CITY OF ALBUQUERQUE

Re: Certification Submittal for Certificate of Occupancy for
Eagle Rock Business Center, 6401 Eagle Rock Avenue NE
Architect's Stamp dated 9-06-07 (C18-D080)
Certification dated 12-12-08

The Letter of Certification submitted on 12-18-08 is not sufficient for acceptance by this office for final Certificate of Occupancy (C.O.). The following items need to be addressed:

SITE DEVELOPMENT PLAN FOR BUILDING PERMIT

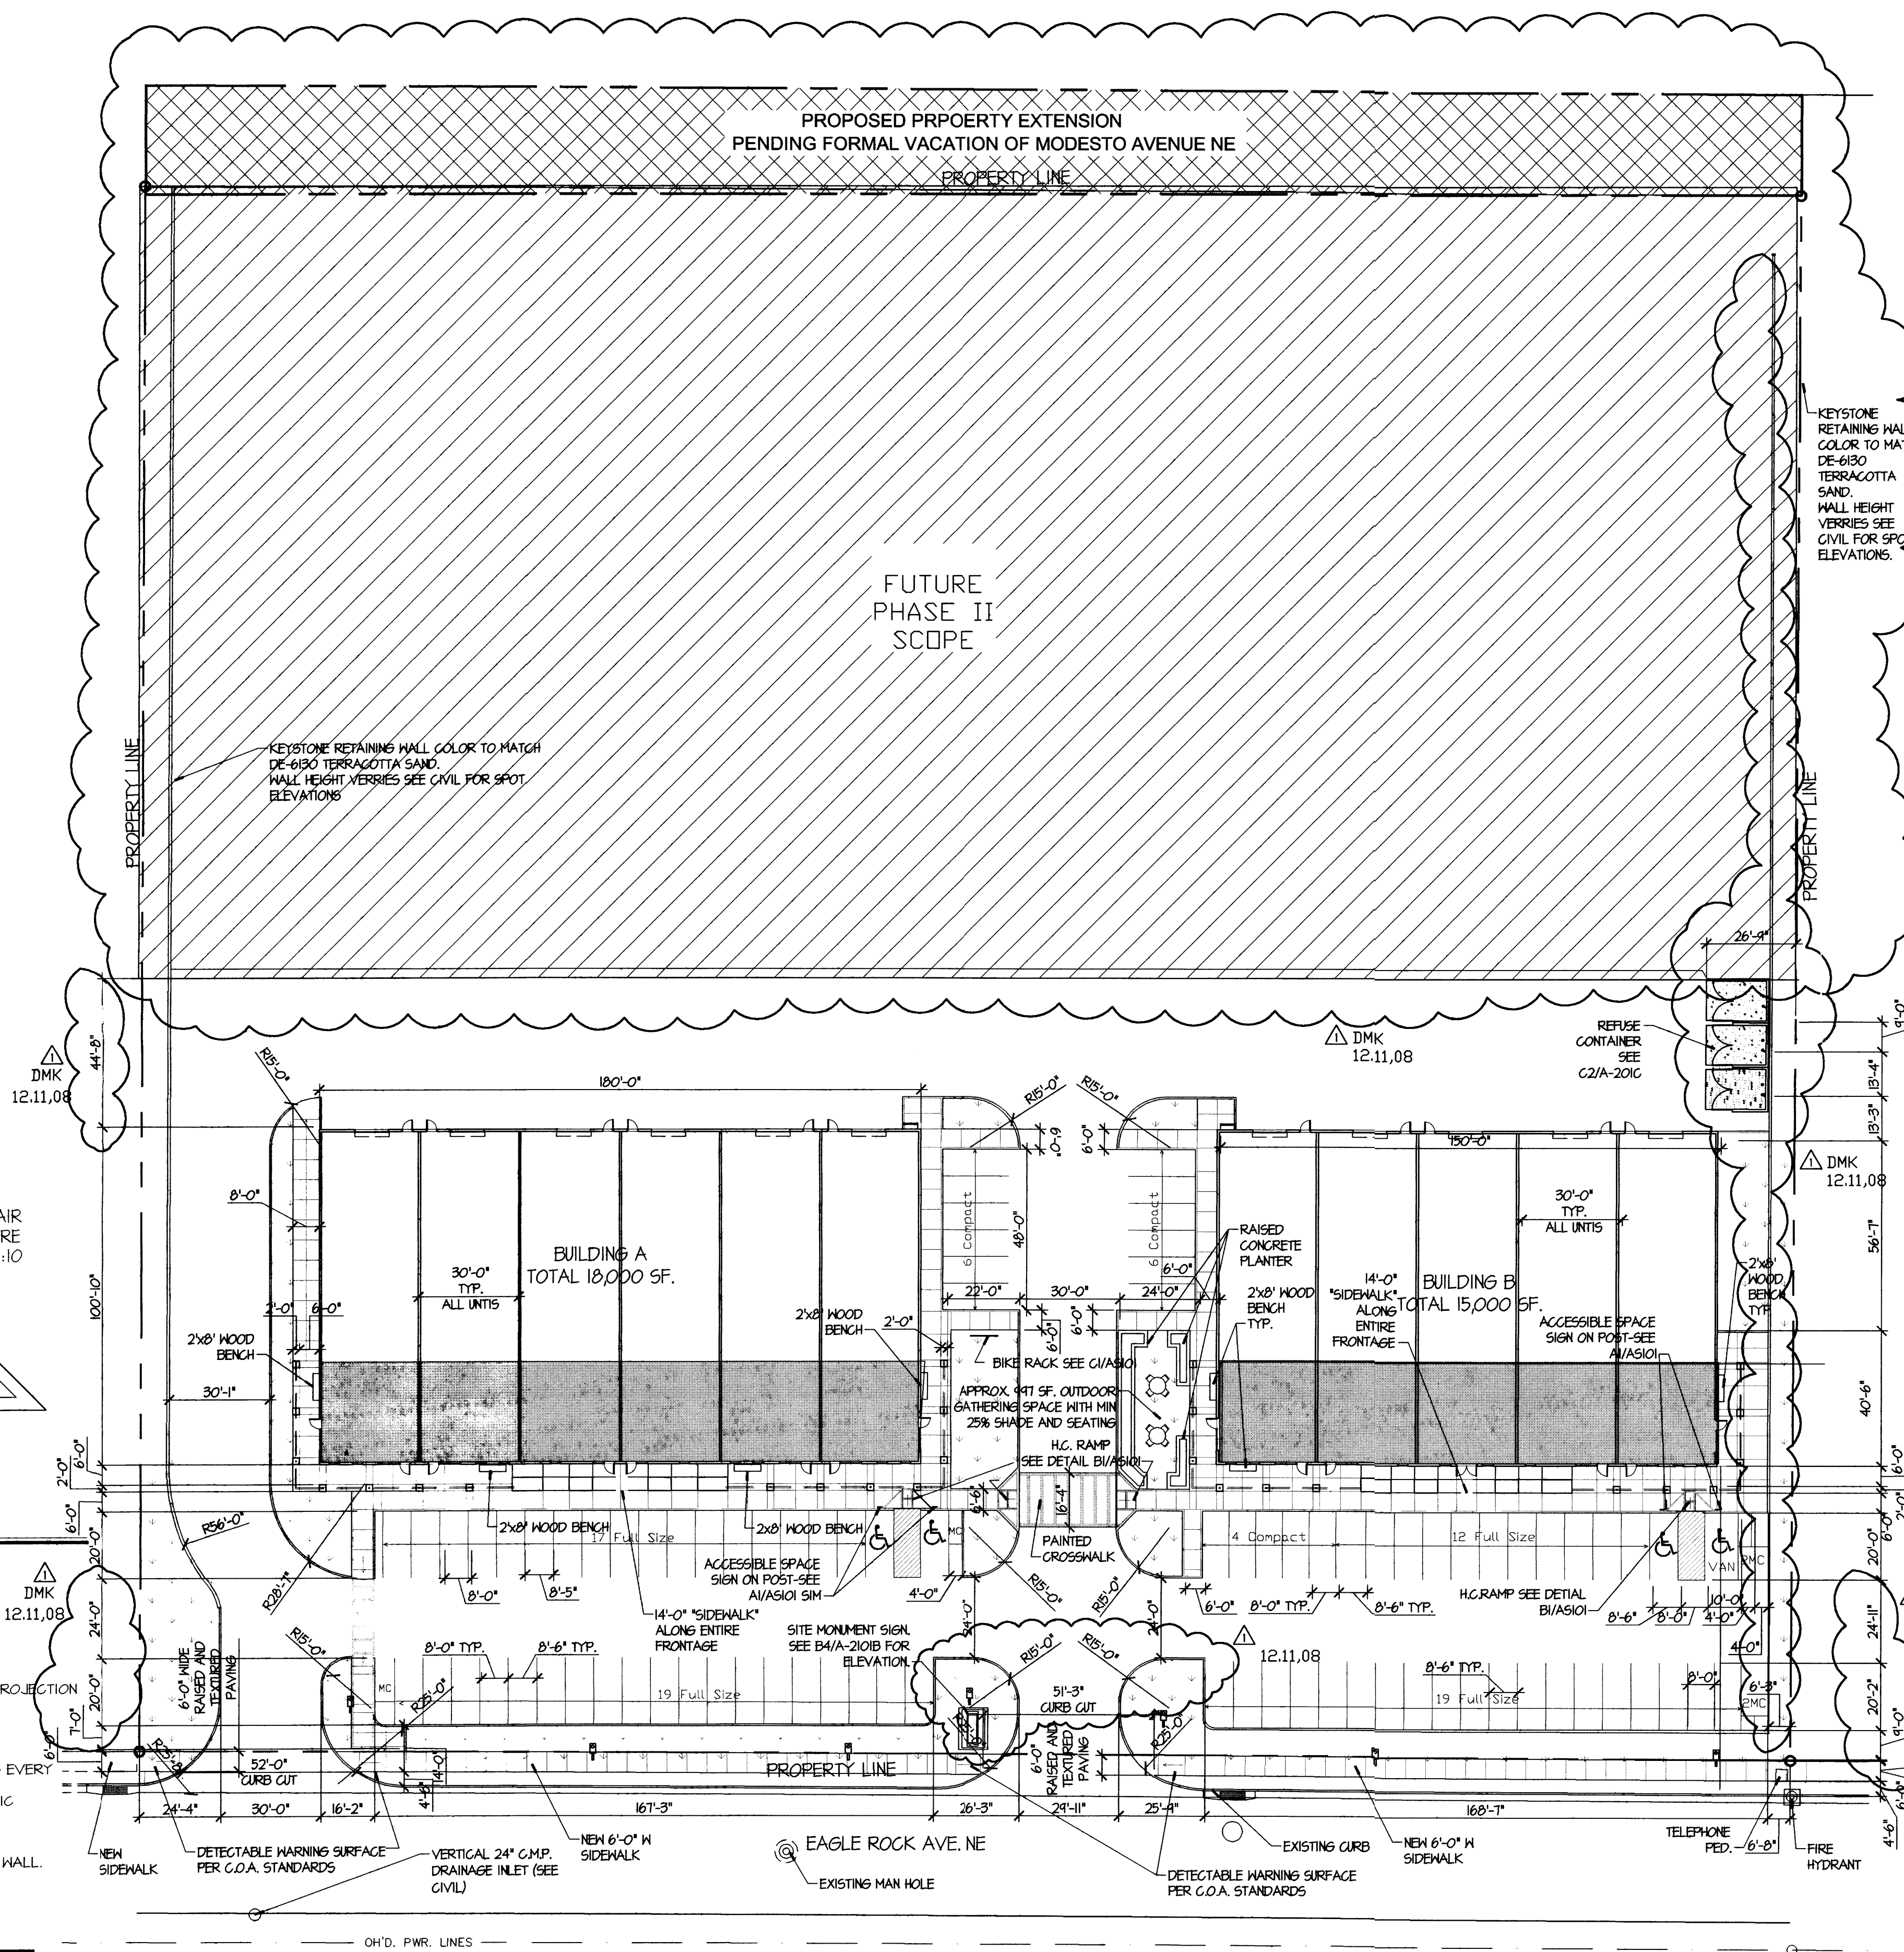
- As previously discussed, a permanent certificate of occupancy cannot be issued on a site that is only partially built. The DRB approved site plan for building permit shows this project as one phase. To gain permanent certificate of occupancy approval in phases, the site plan must be amended.
- All redlined items, indicating changes made during construction, must be shown on the DRB approved site plan. Limits of current construction must be clearly indicated.
